From: Graham Evans
Sent: 17 February 2012 14:17
To: Planningecons
Subject: FW: Planning Consultation on: BR/37/12/
 No objection in principal from Environmental Health.

APPLICATION NO: BR/37/12/

Registered: 08-FEB-12
Site Address: First & Second Floors Queensway House Queensway Bognor Regis PO21 1QT

Description of Works: Conversion of first and second floors of Queensway House to create 6 no. 2 bed dwellings and 10 no. 1 bed dwellings

Drawing
Proposed Ground and First
Floor Plans. Section

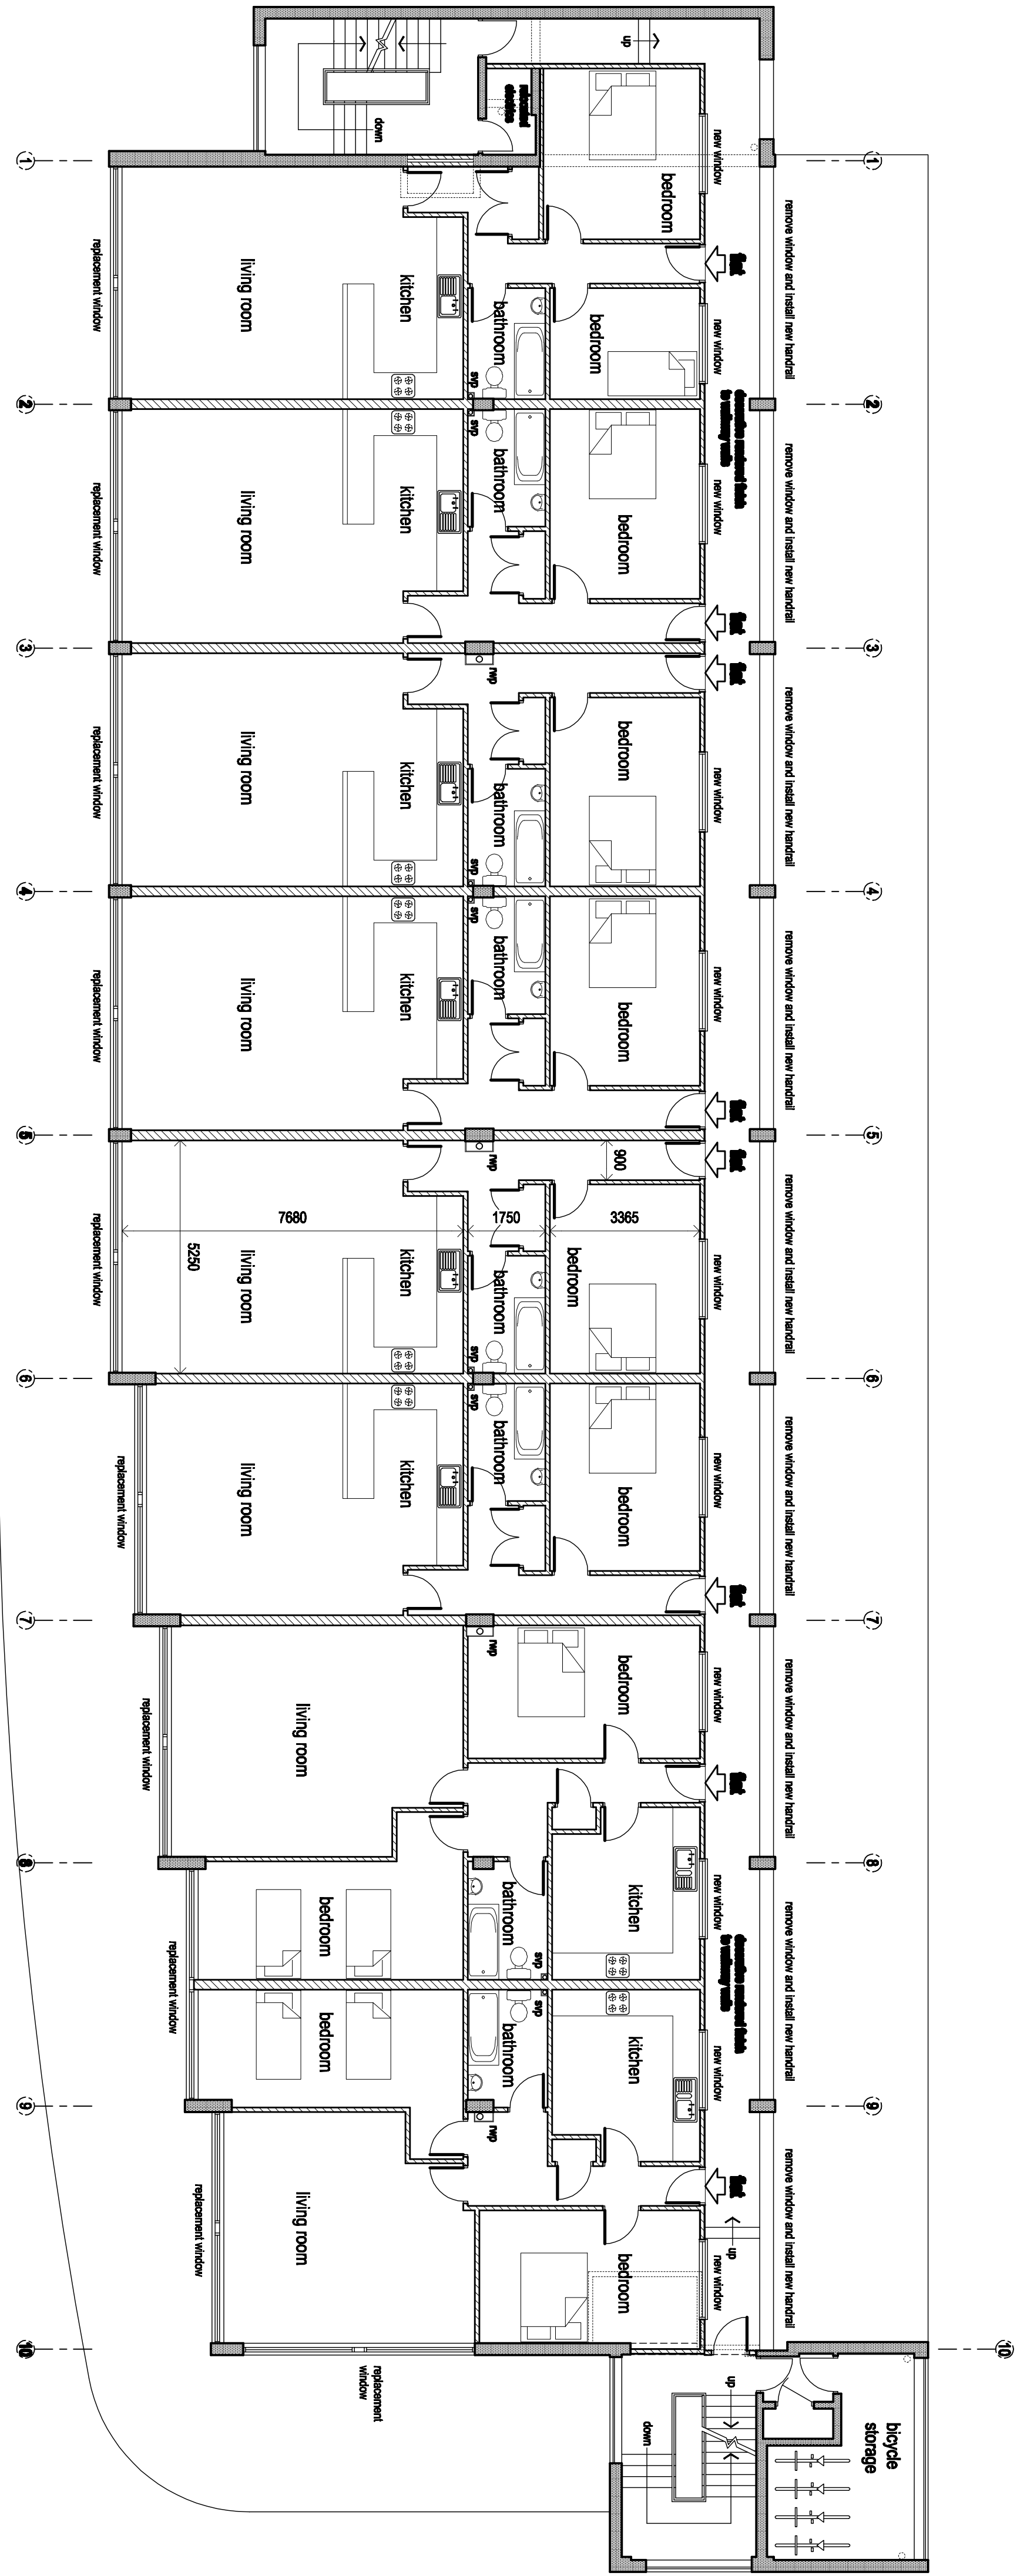
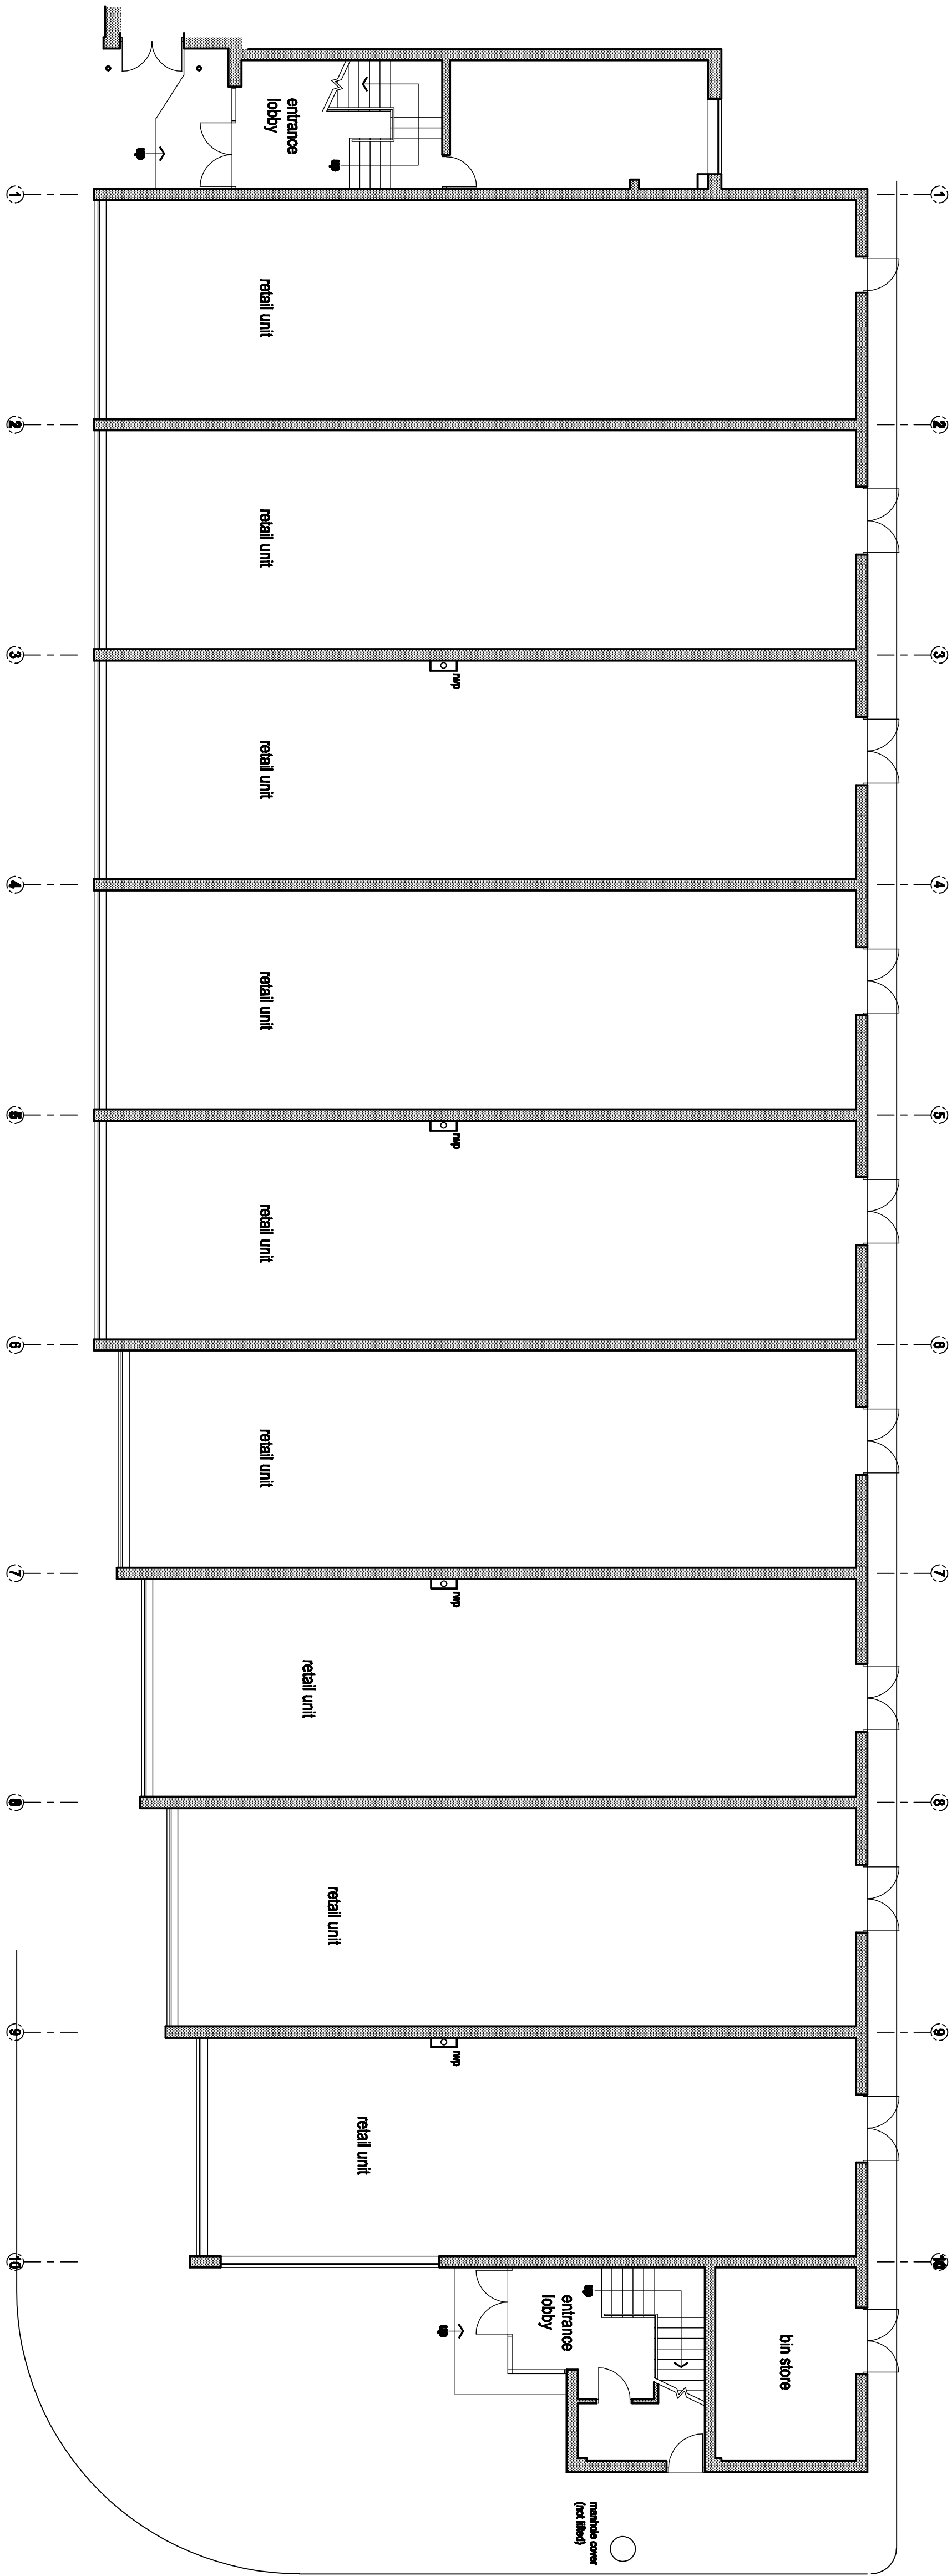
There is potential for noise from existing unspecified commercial uses at ground floor level to adversely impact upon the proposed dwellings. Details of the existing floor/ceiling partitions are not available should be required together with proposals for improving sound insulation.
 The floor/ceiling partition between proposed 1st and 2nd floor residential premises may be subject to Building Regulation sound insulation requirements. A suitable airborne sound insulation test may be necessary to confirm that the floor/ceiling partition at 1st & 2nd floor levels comply at least to Building Regulation standards for insulation between dwellings.
